**KIRKLEES METROPOLITAN COUNCIL
INVESTMENT & REGENERATION SERVICE**

DELEGATED DECISION TO DETERMINE PLANNING APPLICATIONS

Reference No:	2024/62/92103/W
Site Address:	Pennine Foods Ingredients Ltd, Crosland Road, Oakes, Huddersfield, HD3 3PA
Description:	Erection of storage building and associated works
Recommending Officer:	Katie Chew

DECISION – CONDITIONAL FULL PERMISSION

DRAWING DESCRIPTION		
EXISTING & PROP ELEVATIONS		
JOB TITLE		
PENNINE FOODS, CROSLAND RD HUDDERSFIELD HD3 3PA		
CLIENT		
PENNINE FOODS		
DRAWN BY	SCALE 1:100 @ A1	
DATE	DRAWING NO.	REVISION
APRIL 2024	2042-00-02	-
CHECKED

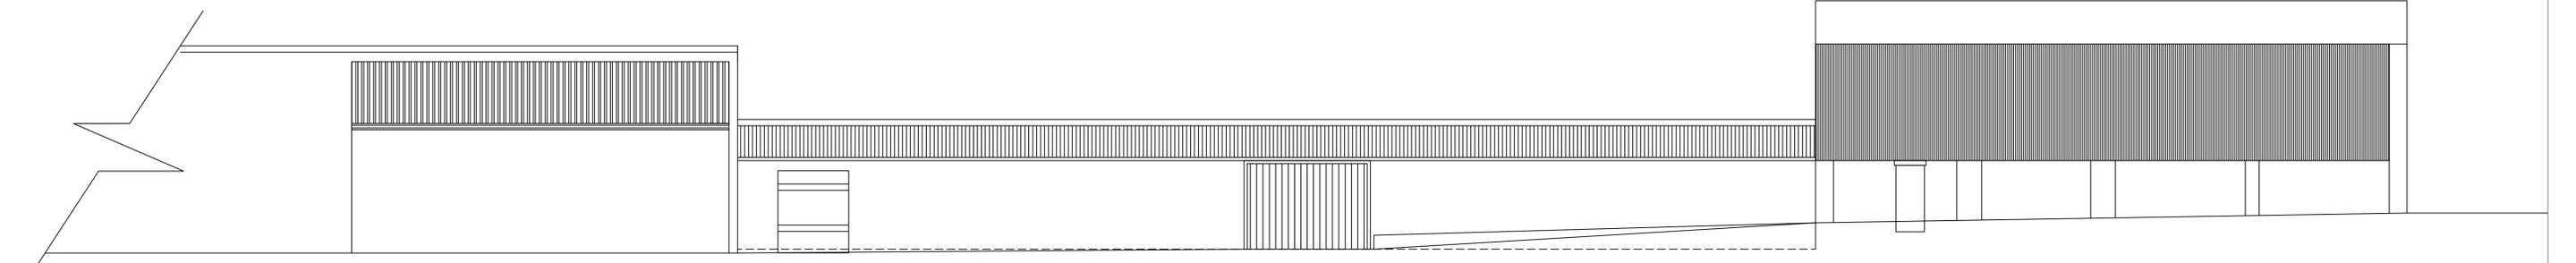
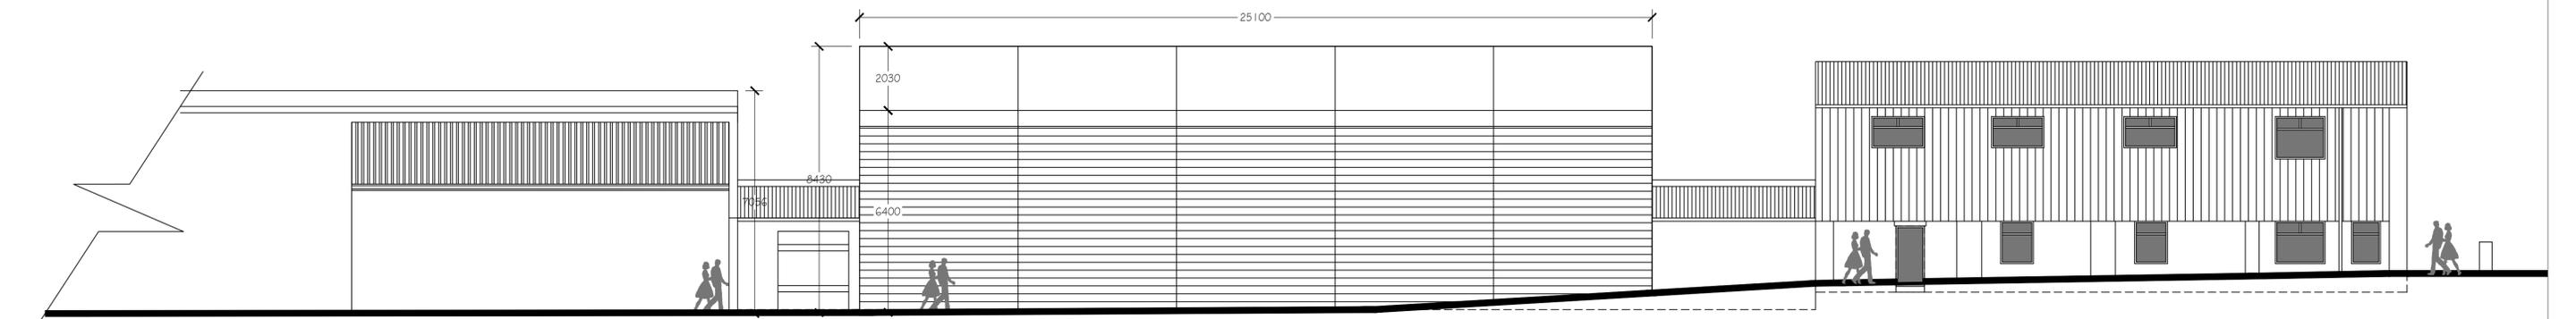
KC Highways Development Management (informal) – Comments received 23rd October 2024. No significant concerns other than Officers requested the submission of additional information/clarification on where the existing bins are to be stored at the site and where the existing 6 parking spaces shown to the rear of the site are to be moved to.

Officer note: Following receipt of the above comments, the applicant and applicant's agent sought to provide additional information via email, this is discussed in more detail within the highways section of this report. They also provided an amended site plan which showed the location of the waste storage areas. Highways Officers considered the submission of this information to be acceptable and that the servicing arrangements are unchanged by these proposals; the existing parking demand is low and the numbers of HGVs using the access is low. Highways Development Management have therefore no further objection to these proposals.

DRAWING DESCRIPTION	
PROPOSED ELEVATIONS	
JOB TITLE	
PENNINE FOODS, CROSLAND RD HUDDERSFIELD HD3 3FA	
CLIENT	
PENNINE FOODS	
DRAWN BY	SCALE 1:100, 1:500 @ A1
DATE	DRAWING NO. REVISION
APRIL 2024	2042-00-02 -
CHECKED

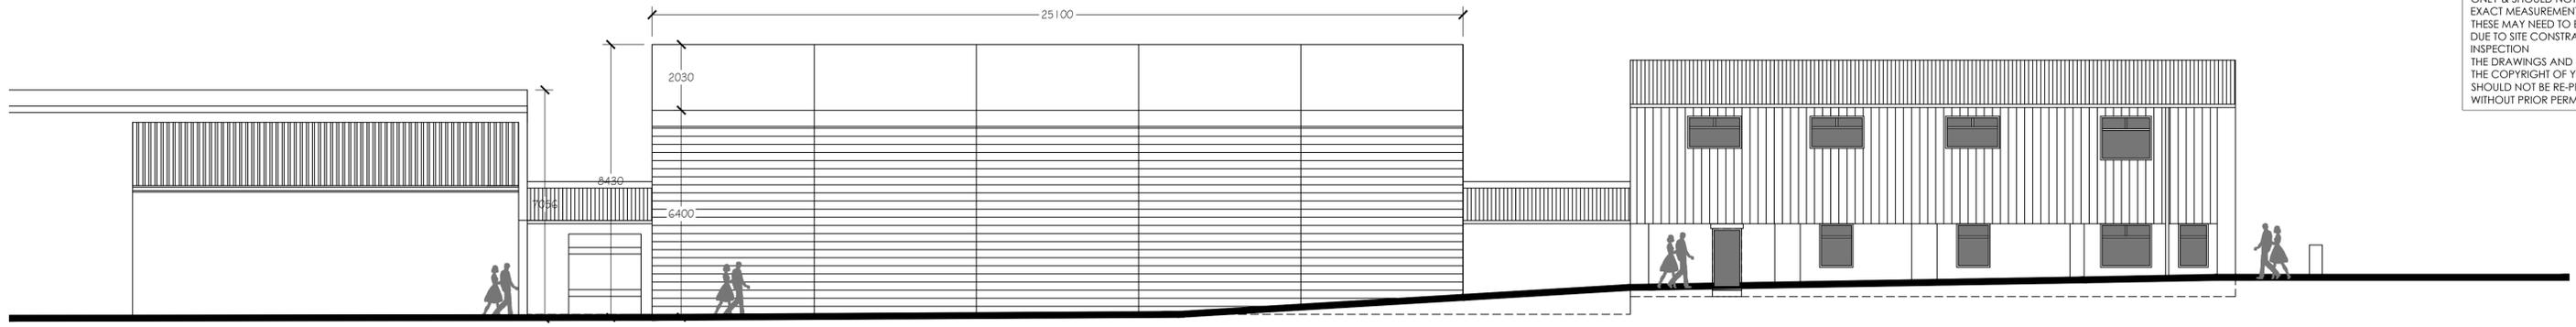
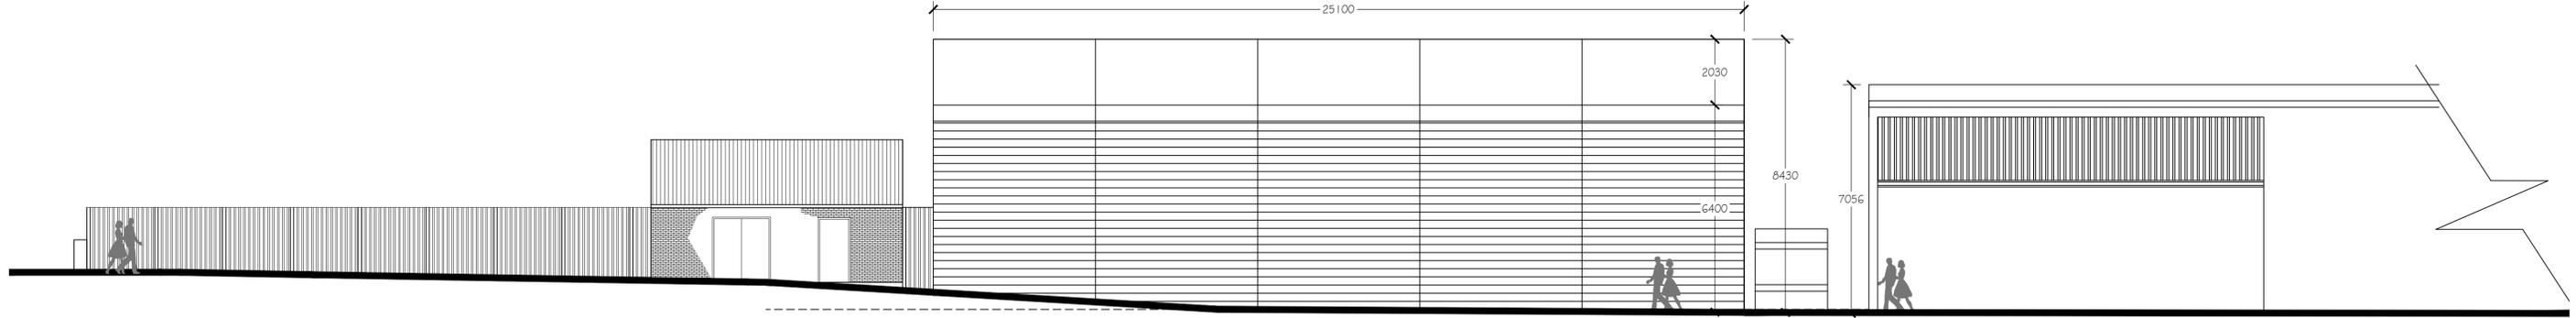
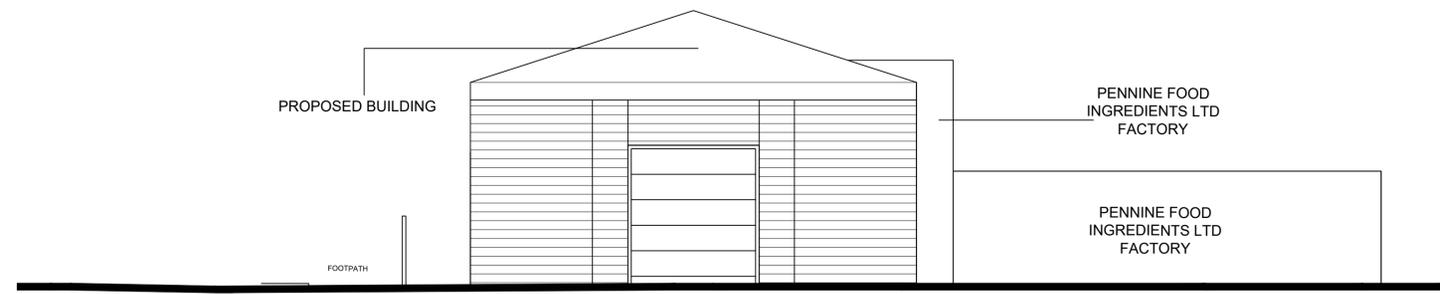
Amendments were sought to reduce the overall height of the proposed building down, to be more in line with adjacent buildings in the interests of both visual and residential amenity. Further information was also requested in respect of bin storage and the displacement of 6 existing parking spaces to the rear of the site.

the originally submitted building by around 1.4m and therefore it was not considered reasonable or necessary to re-consult third parties again in this instance.

The application concerns the erection of a semi-permanent building for storage purposes. The proposed storage building will be located to the north of the existing buildings on site currently used in accordance with the Pennine Foods Ingredients Ltd business. The building will be constructed on land which currently comprises of hardstanding and will be rectangular in form. The building is to measure approximately 25.1m x 10.14m and will have a shallow pitched roof. The building will be single storey with a ridge height of around 7.03m, and an eaves of around 5.4m.
